Re: **Wyoming Mall-Starbucks**
Project #: PR-2021-005461
Application #: SI-2023-01170

Please find the following responses addressing comments received in a letter dated July 18, 2023. In an effort to address your comments concisely and simplify your review of these development plans, we have summarized your comments and our responses below. Your comment is listed first, followed by the response in Bold.

SHEET TITLE:
EXTERIOR ELEVATIONS

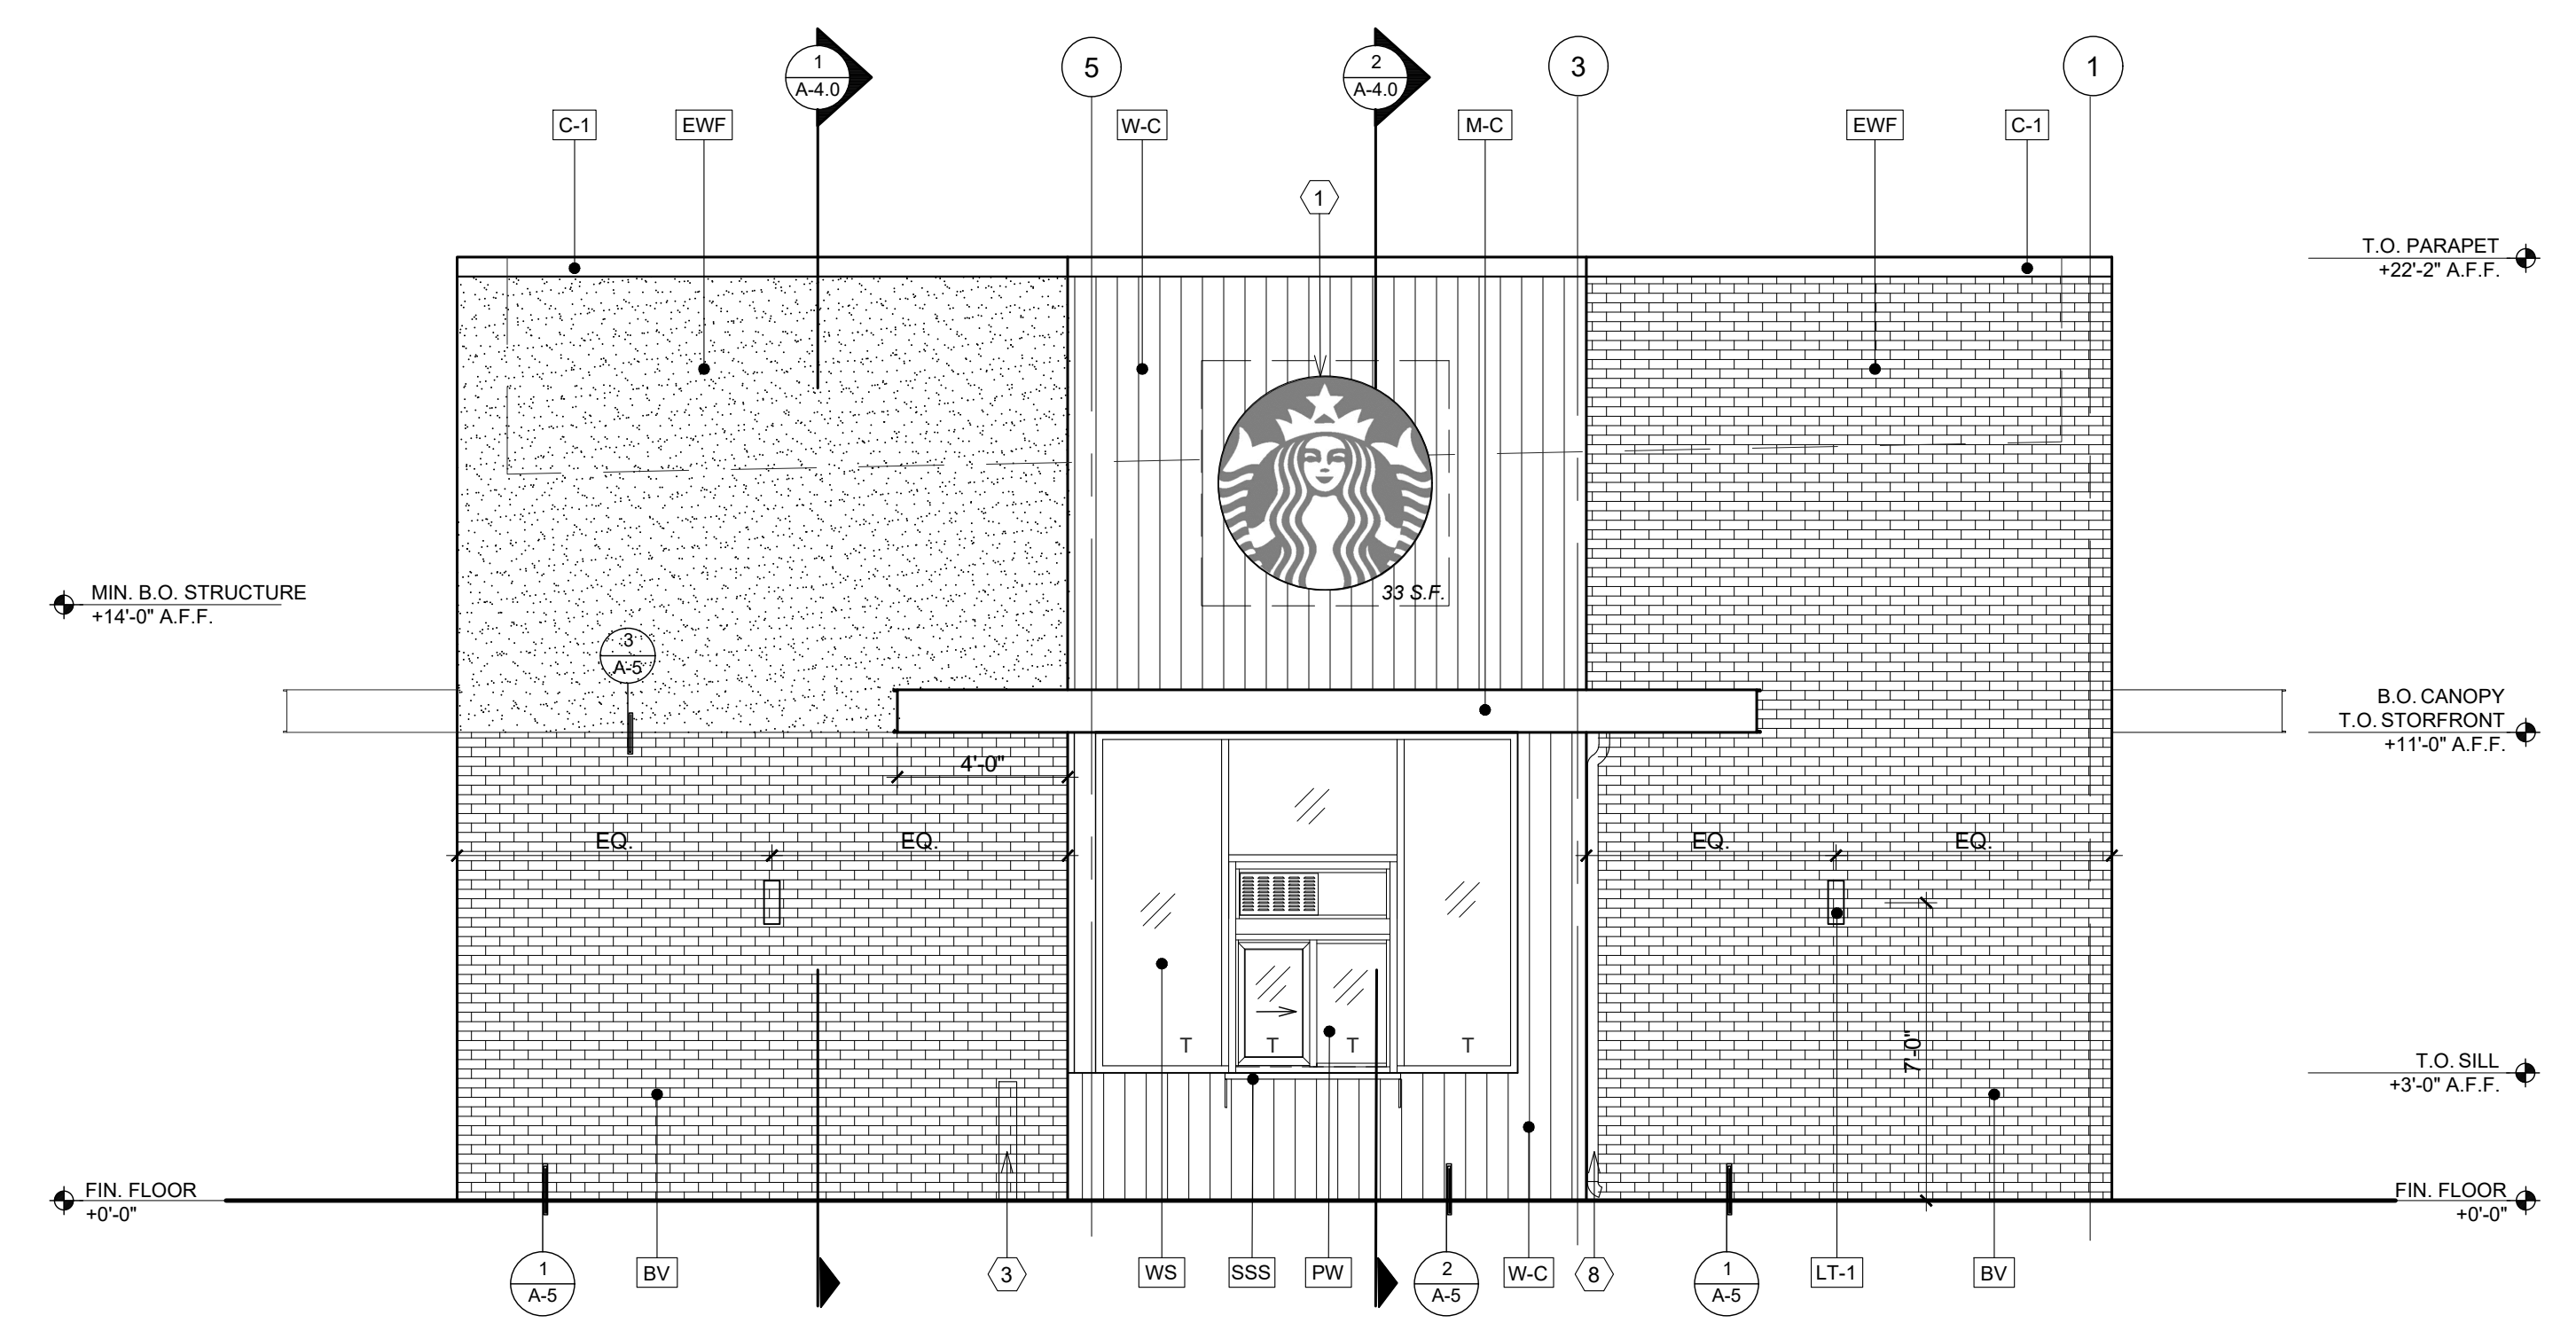
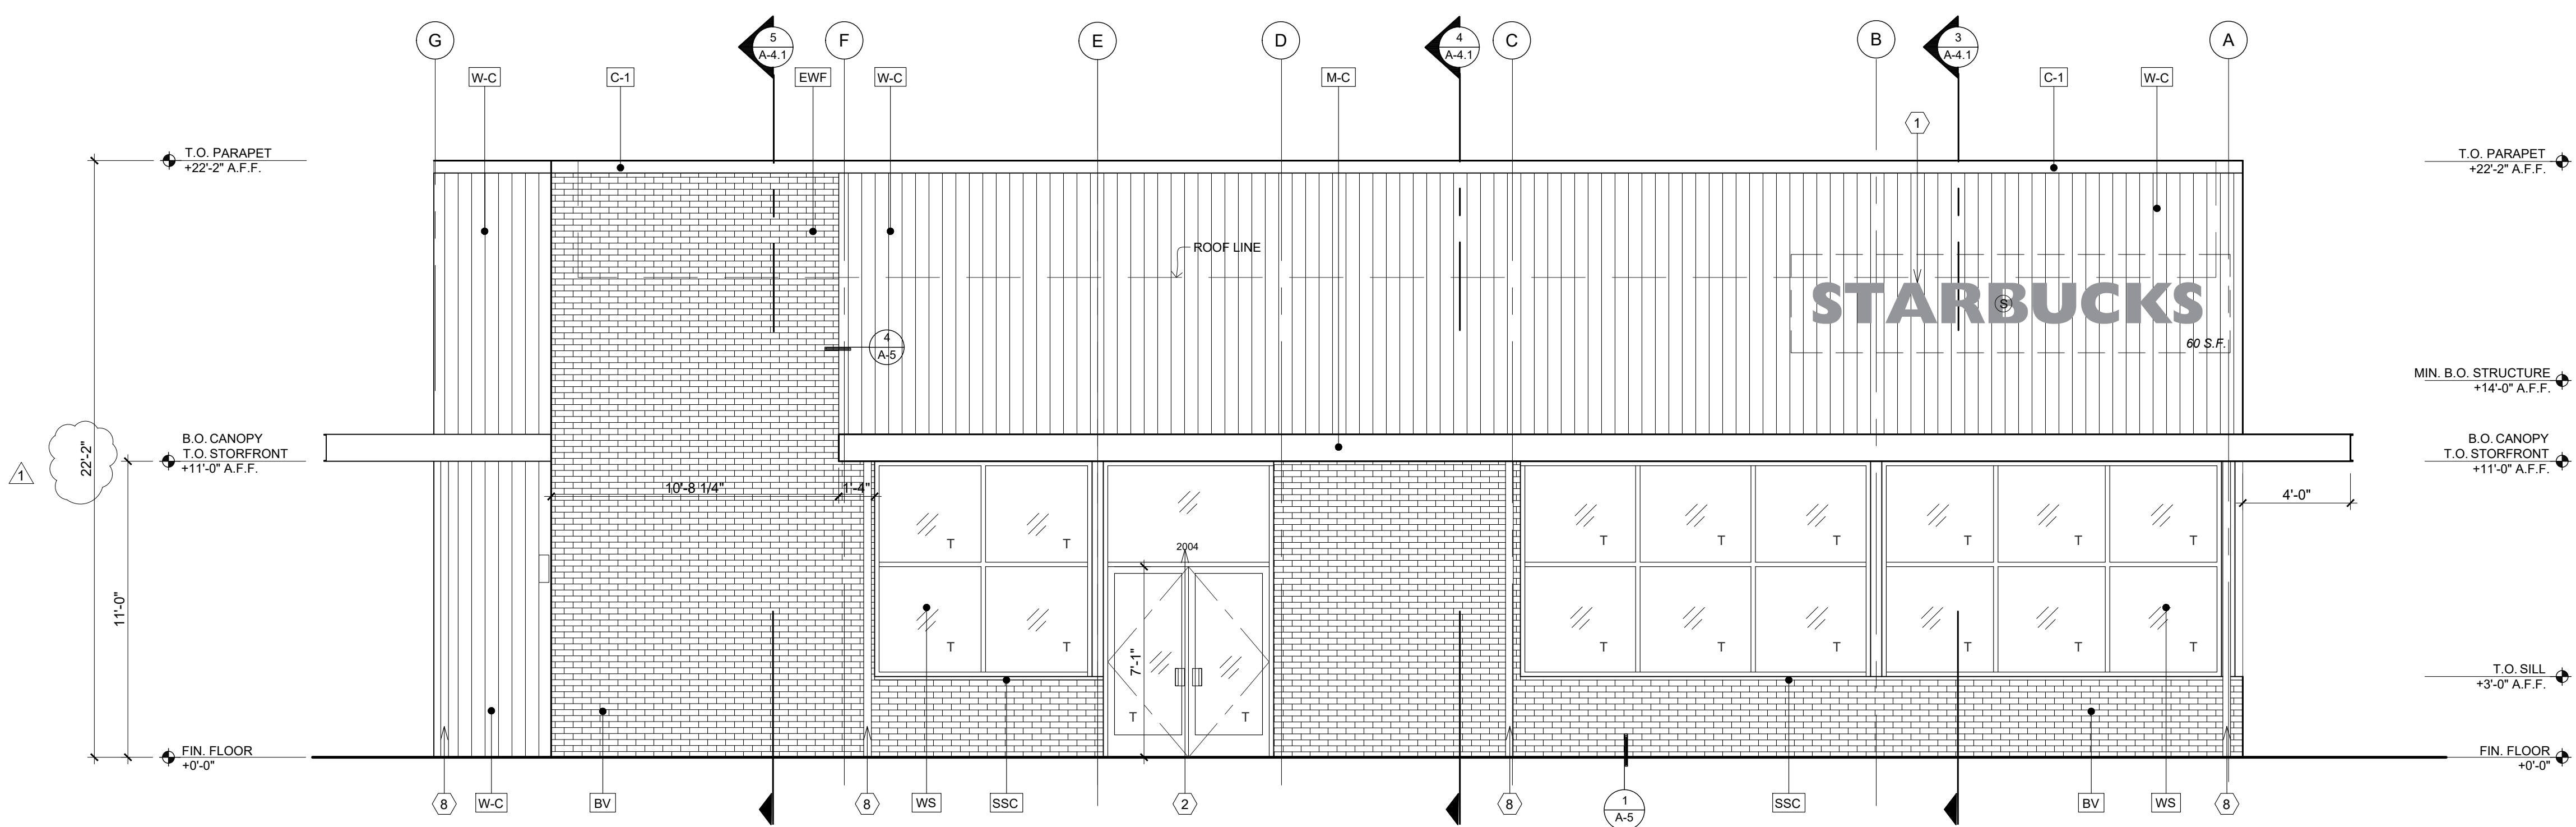
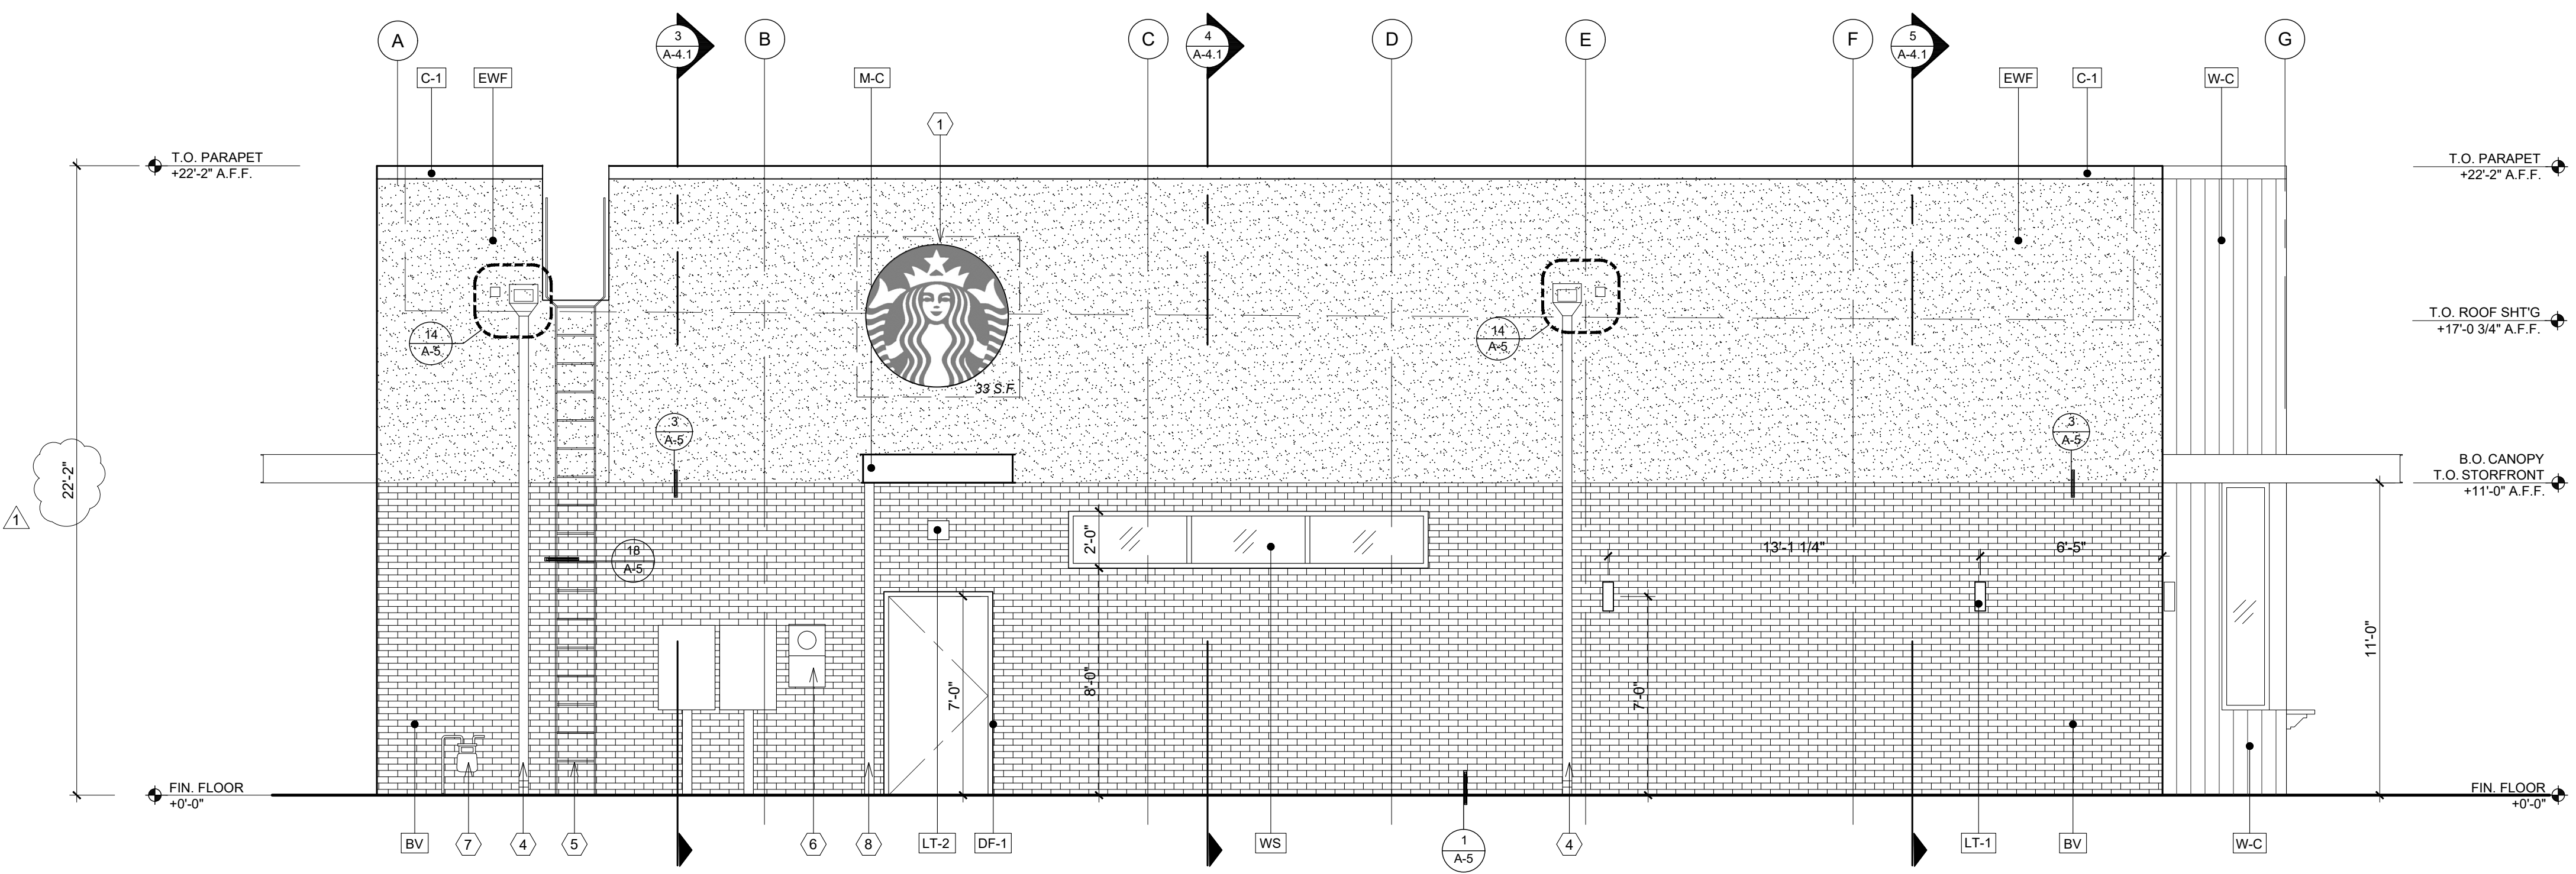
Comment 7: Please provide a detailed explanation letter and include site plan notes as to how the proposed elevation is meeting all applicable sections of 5-11(E) of the IDO.

Comment 8: Some signage was included in the elevation submittal. However, the signage detail was not. Will signage be a part of this review and DFT approval? Or will that be accomplished only during building permit submittal and review?

Response 7: Below is the site plan and the measurements from the street facing façade to the property line. According to the IDO each street facing façade within 30 ft of a property line (the measurement shall be made to the closest perpendicular plane of a primary building façade) has to follow 14-16-5-11(E).

Response 8: Signage will be permitted separately. The signage dimensions meet the IDO standards. A signage percentage table has been provided on the plans see “Sign Data Table”.
